Case Officer: Rebekah Morgan

Proposal: Reserved matters application to 19/01740/HYBRID - layout, scale, appearance and landscaping details for Phase 2 of the employment development (11,309sqm GIA) with associated landscaping and infrastructure works.

DRAWING TITLE			
Vehicle Tracking Unit 5

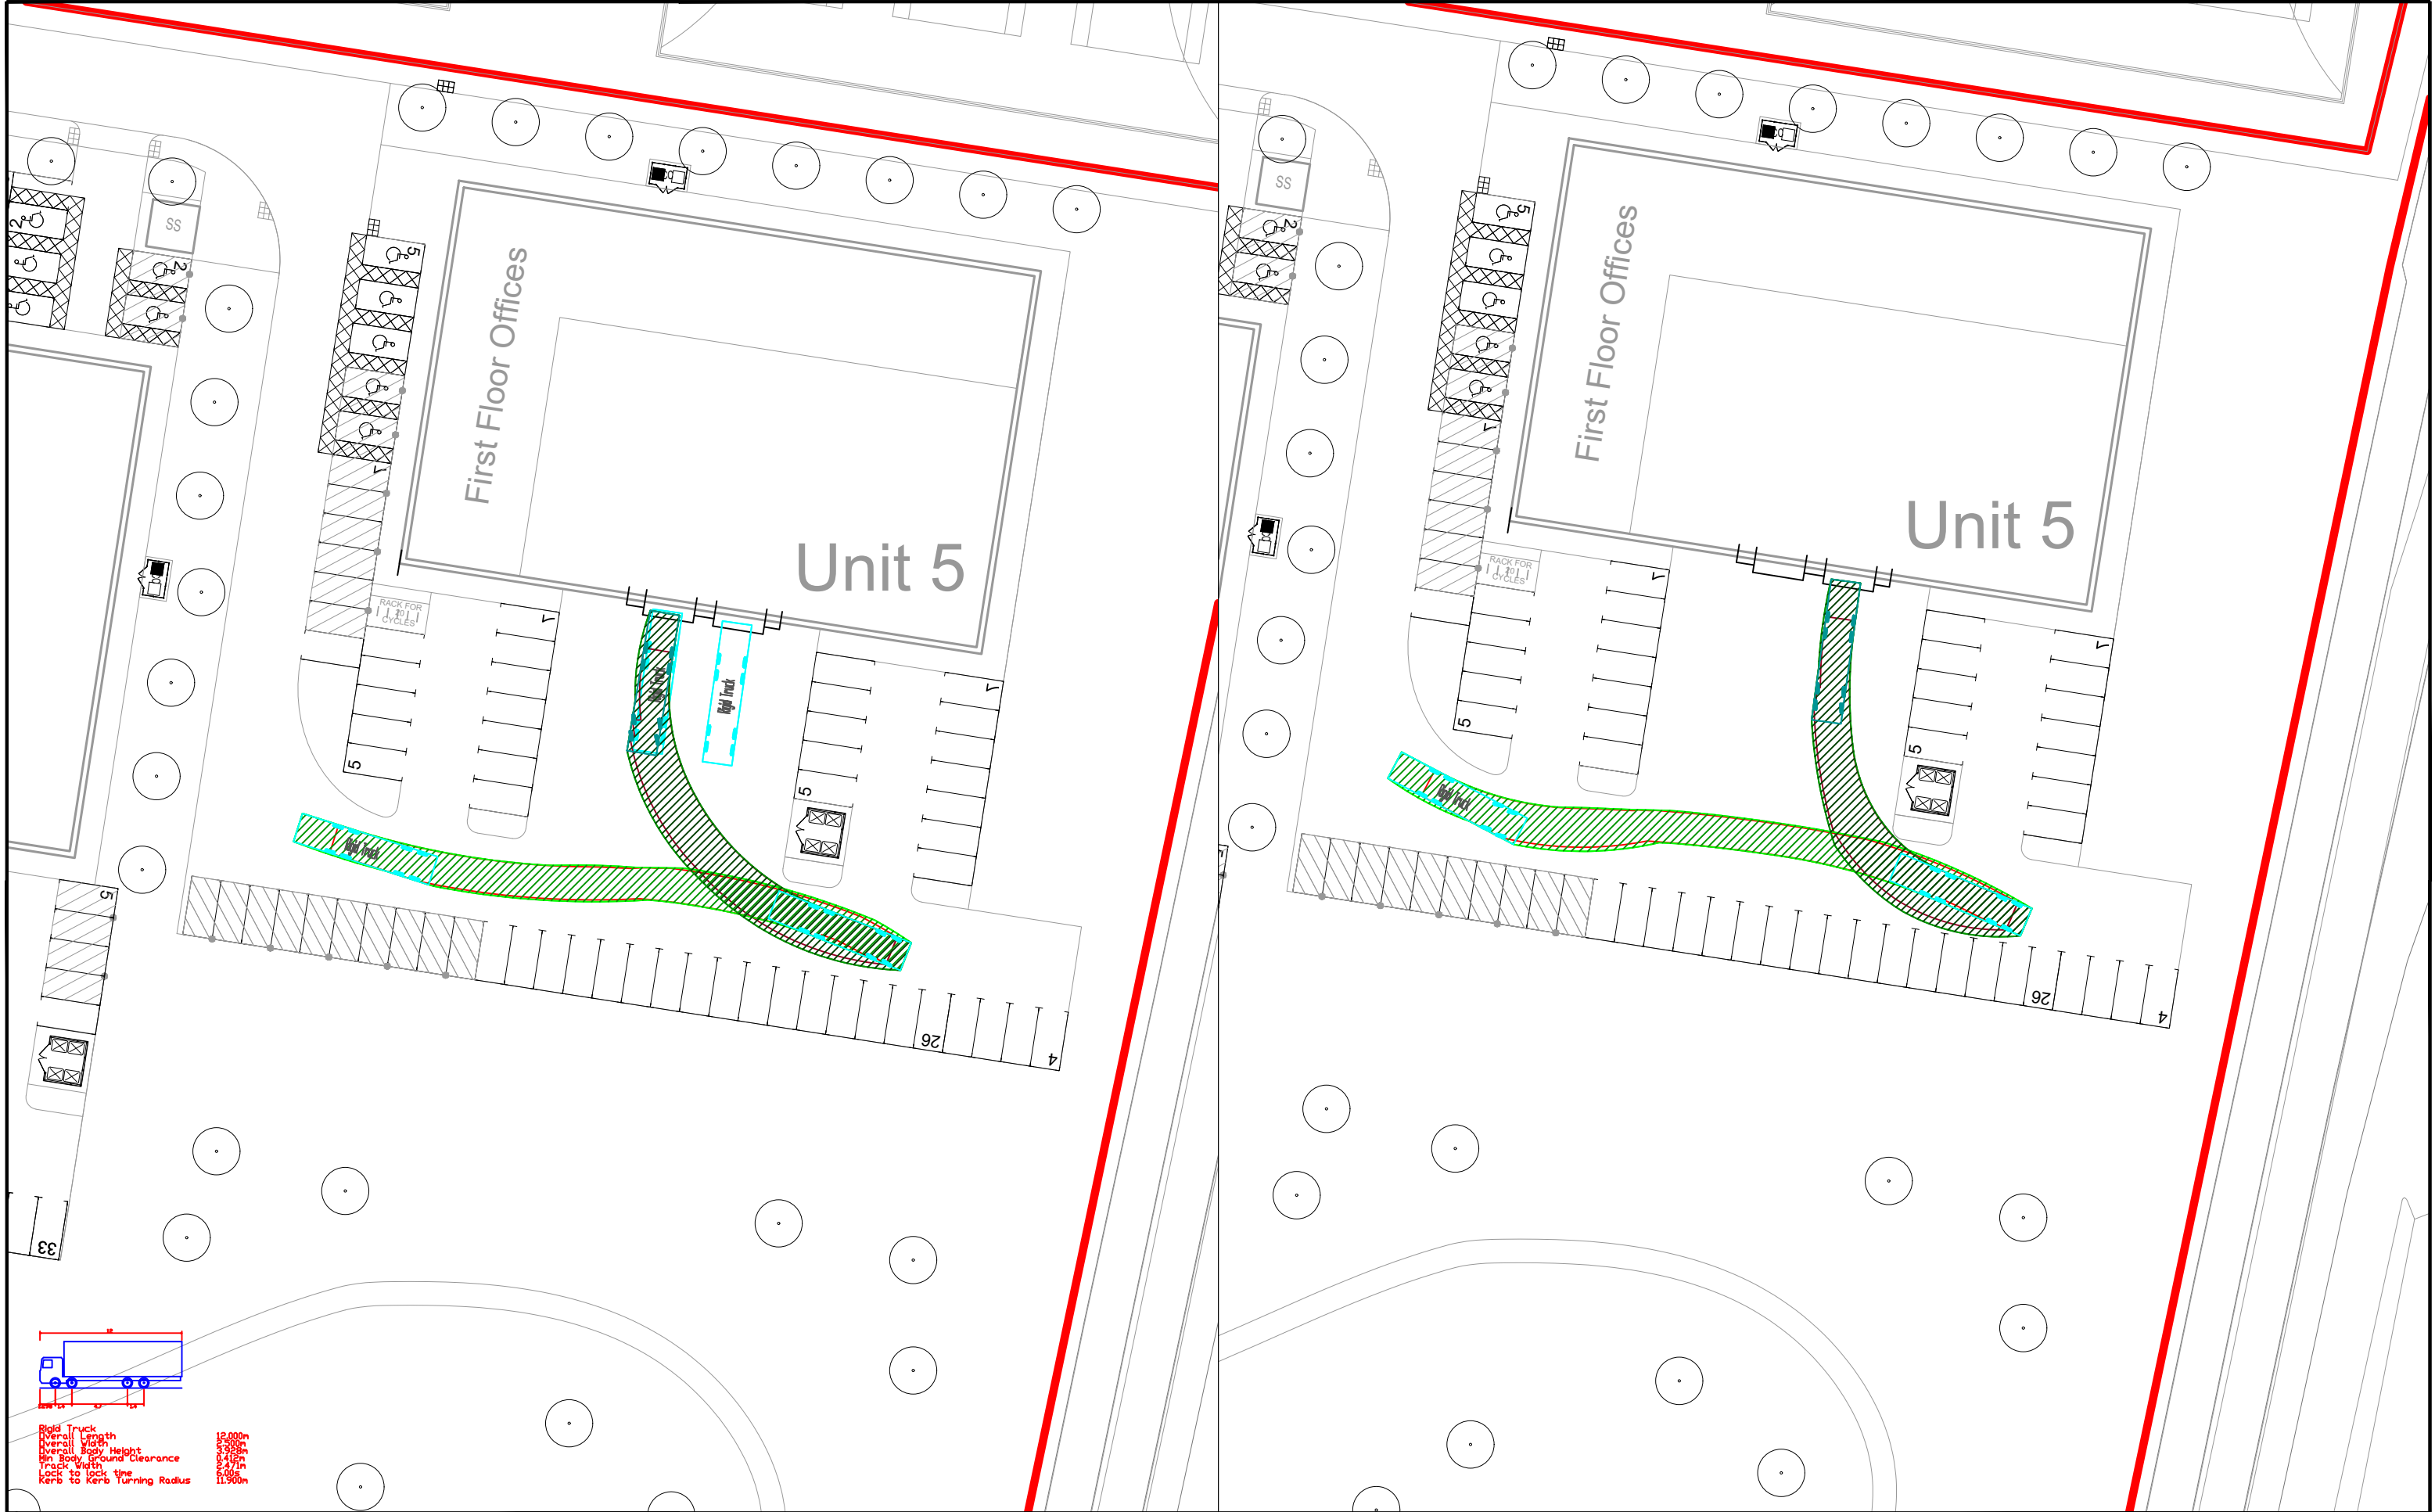
Tracking has been provided for a 16.5m long articulated and a 12m long rigid truck, demonstrating that any such vehicles can ably enter, turn around and egress in a forward gear. This is acceptable.
